**From:** [Pat Nicholson](#)  
**To:** [Rachael Stevie \(CD\)](#)  
**Subject:** RE: BL-20-00006 Flying M Ranch Notice of Application  
**Date:** Tuesday, March 10, 2020 2:29:30 PM  
**Attachments:** [image001.png](#)

**From:** Rachael Stevie (CD) <[rachael.stevie.cd@co.kittitas.wa.us](mailto:rachael.stevie.cd@co.kittitas.wa.us)>  
**Sent:** Tuesday, March 10, 2020 11:46 AM  
**To:** Pat Nicholson <[pat.nicholson@co.kittitas.wa.us](mailto:pat.nicholson@co.kittitas.wa.us)>; Candie Leader <[candie.leader@co.kittitas.wa.us](mailto:candie.leader@co.kittitas.wa.us)>; Holly Erdman <[Holly.erdman@co.kittitas.wa.us](mailto:Holly.erdman@co.kittitas.wa.us)>; Jesse Cox <[jesse.cox@co.kittitas.wa.us](mailto:jesse.cox@co.kittitas.wa.us)>  
**Cc:** Lindsey Ozbolt <[lindsey.ozbolt@co.kittitas.wa.us](mailto:lindsey.ozbolt@co.kittitas.wa.us)>  
**Subject:** BL-20-00006 Flying M Ranch Notice of Application

Please review the following Boundary Line Adjustment application submitted by Flying M Ranch c/o Michael Moeur (BL-20-00006). Any comments need to be submitted by 5pm on March 25, 2020. Please let me know if there are any questions.

SHEET 1 OF 3

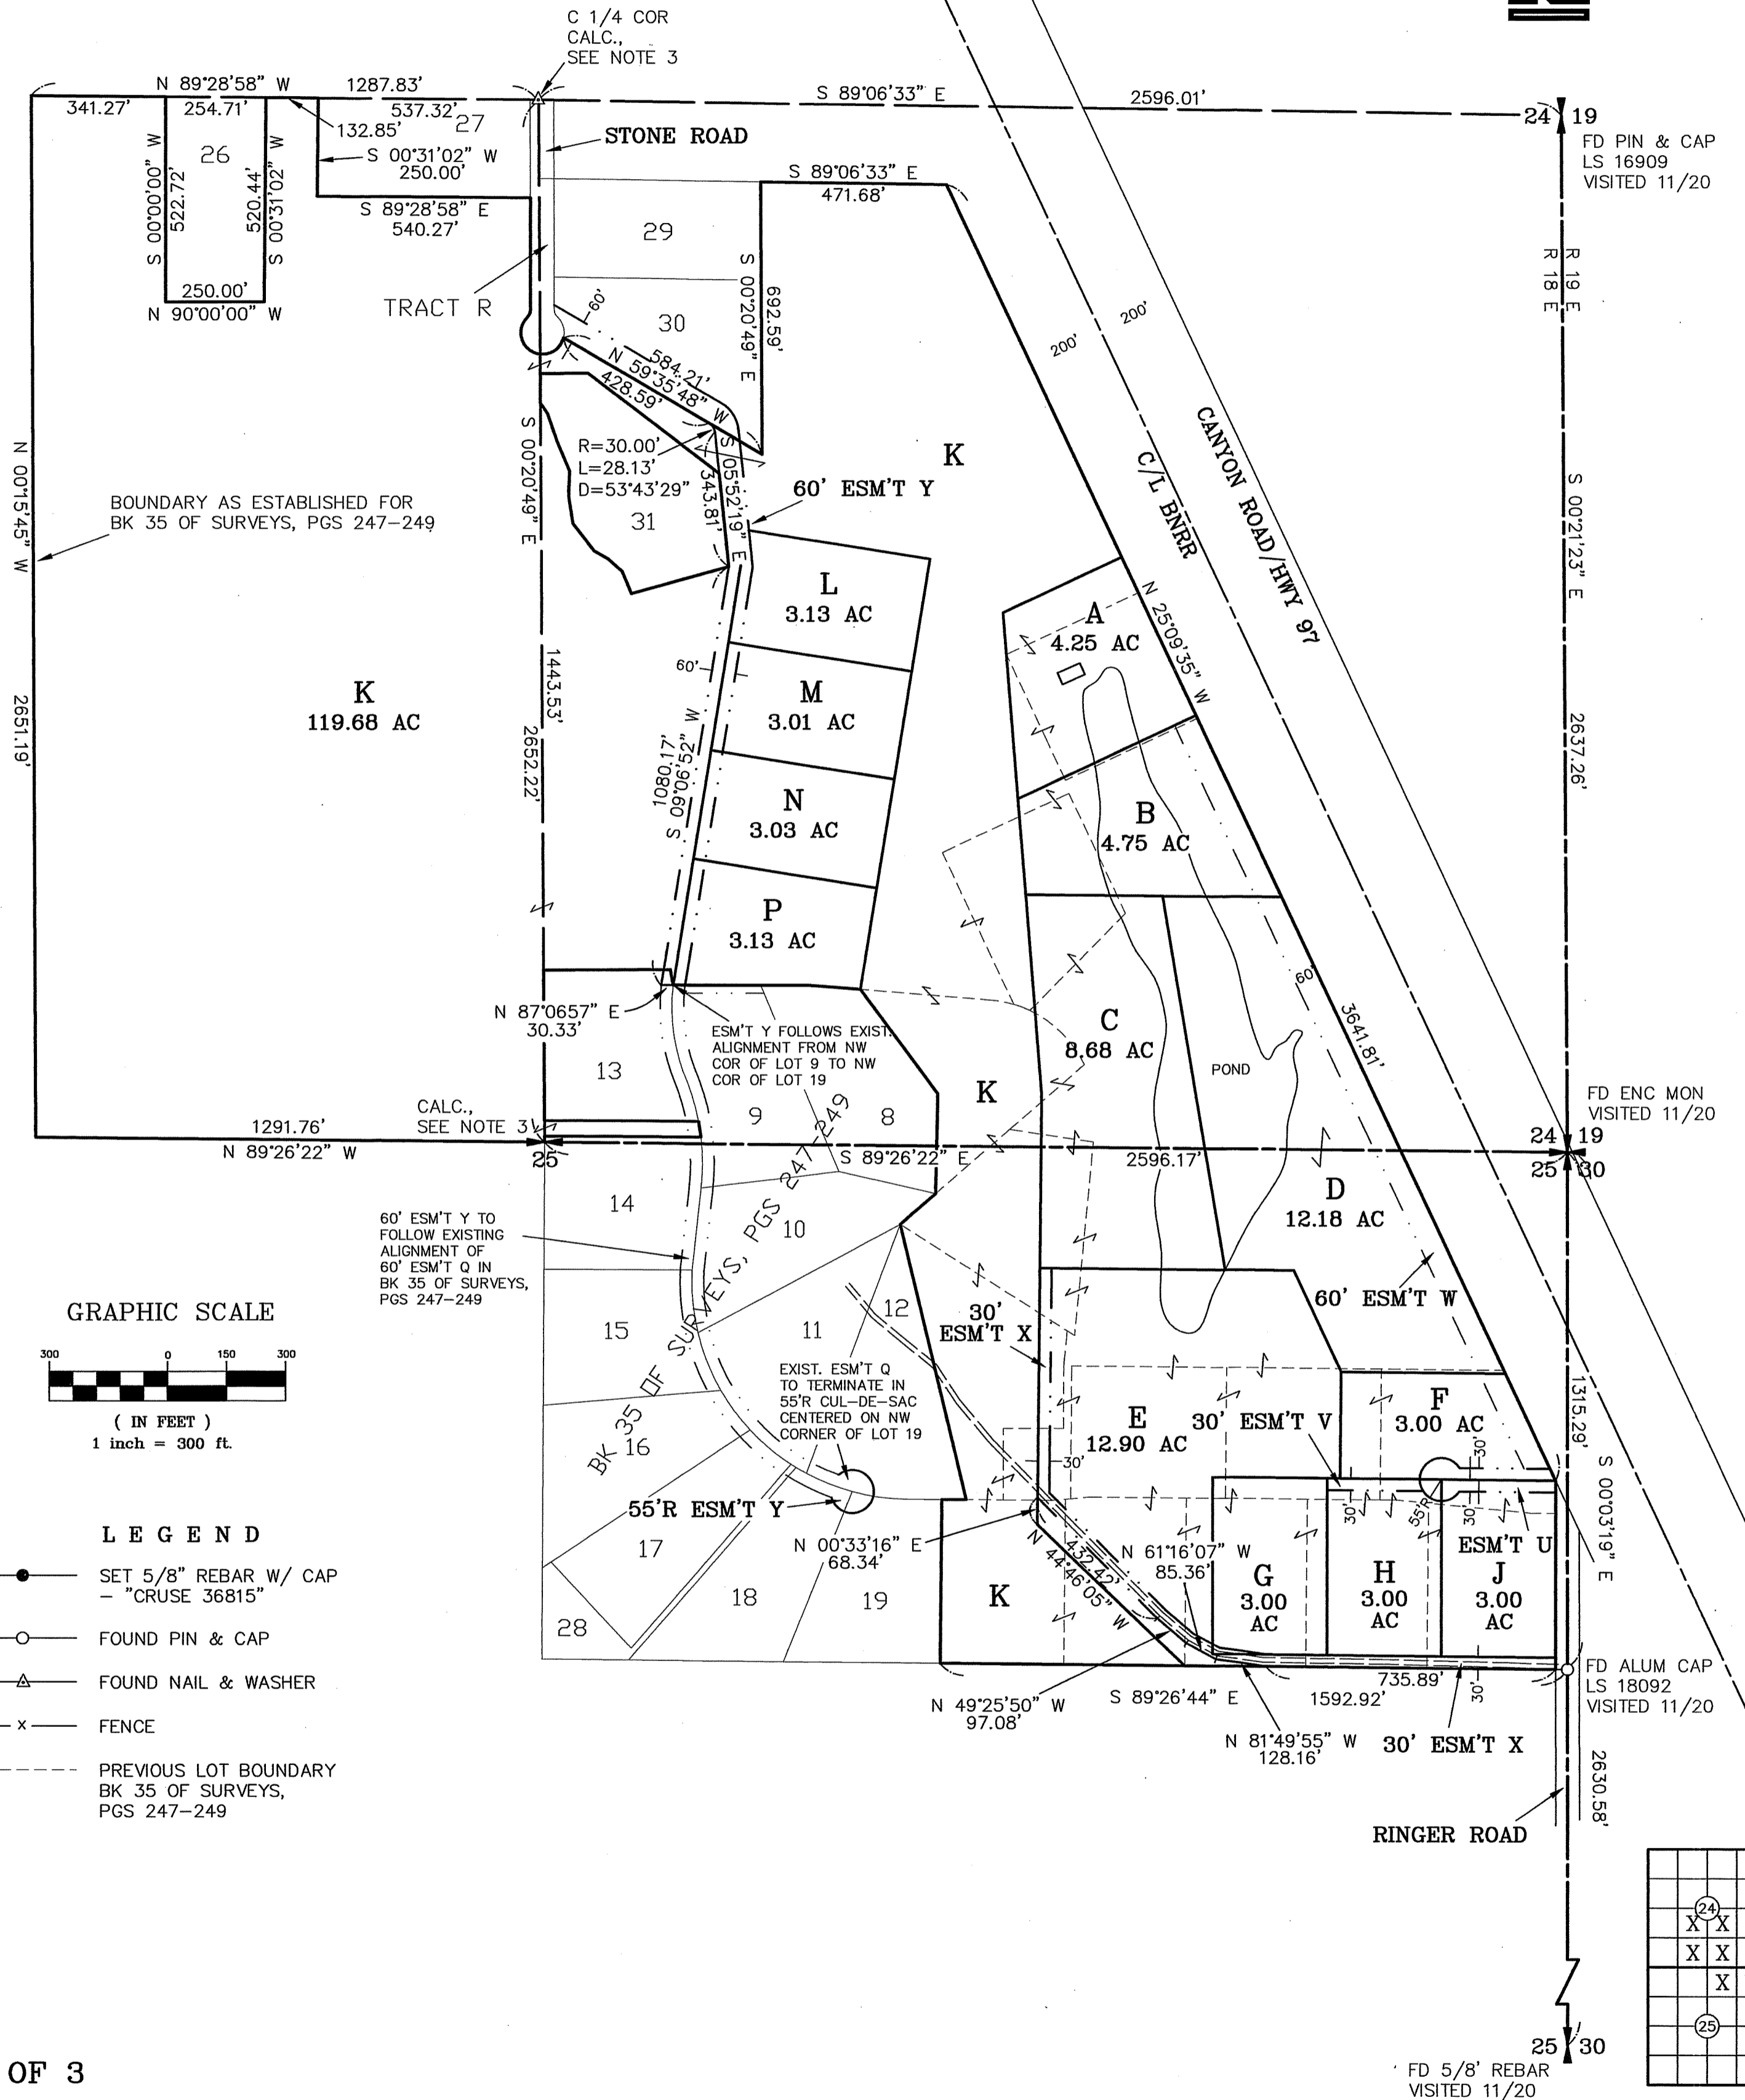
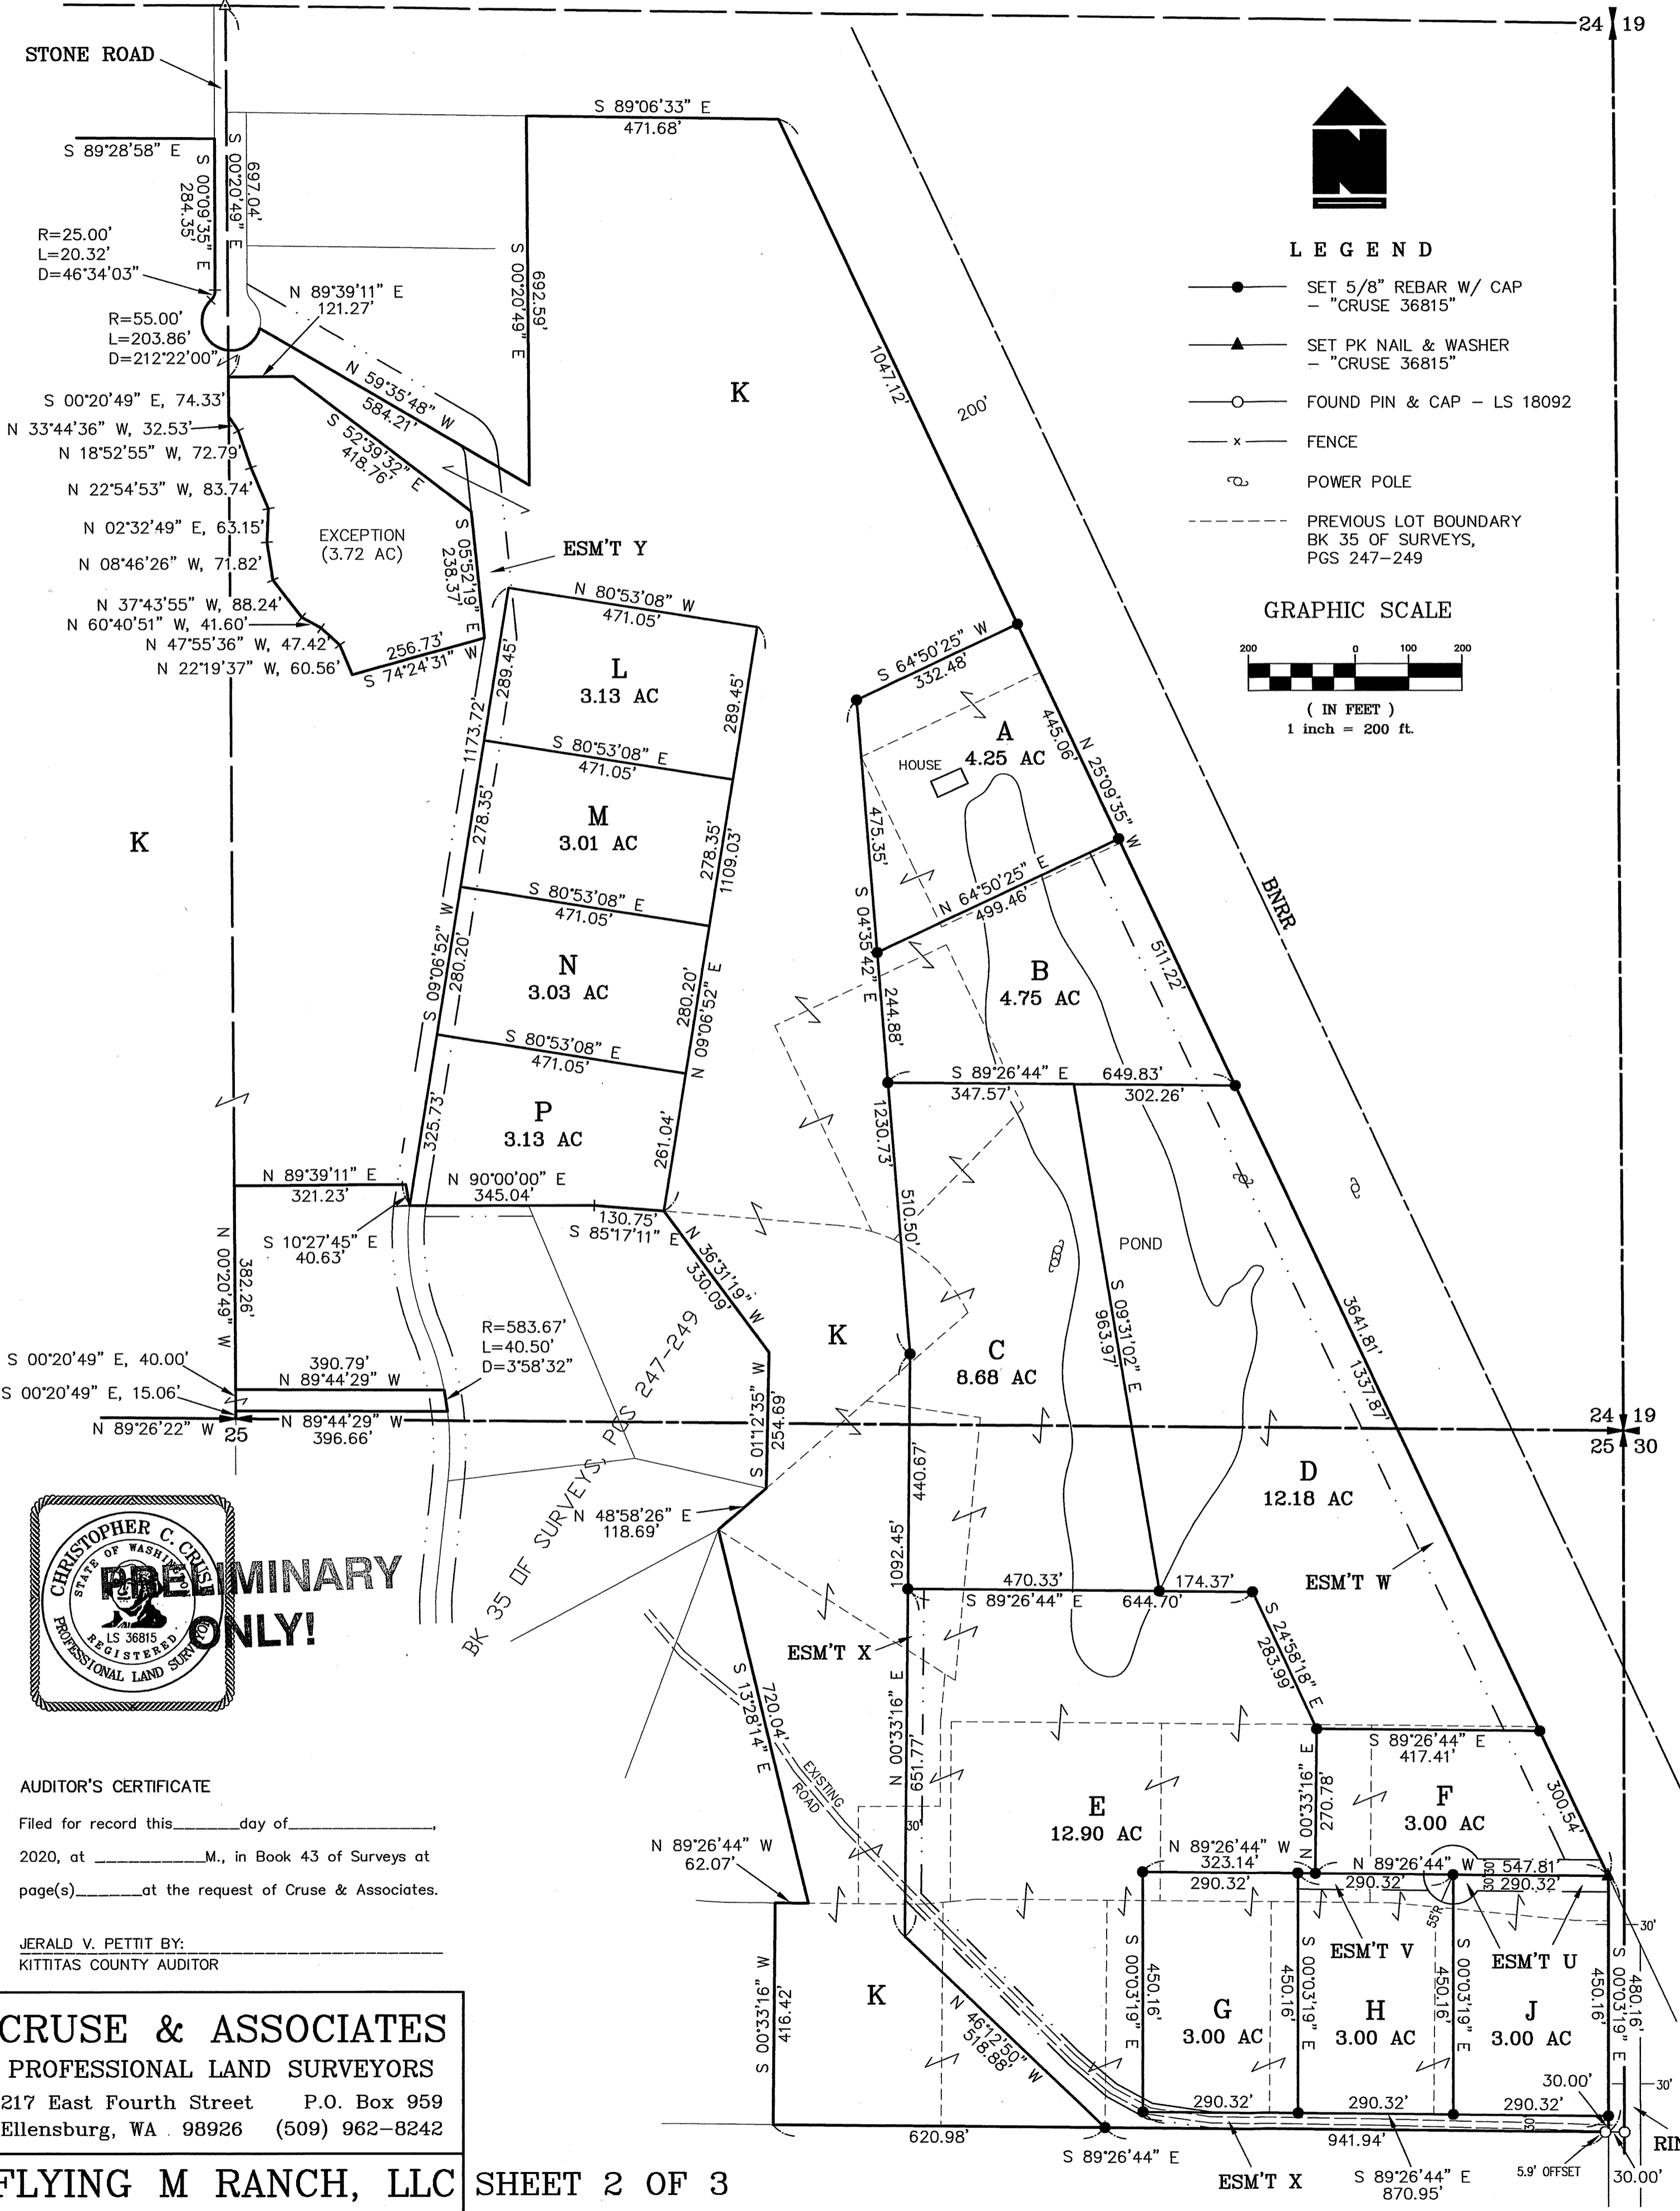
Accesses to be IFC and PW compliant.
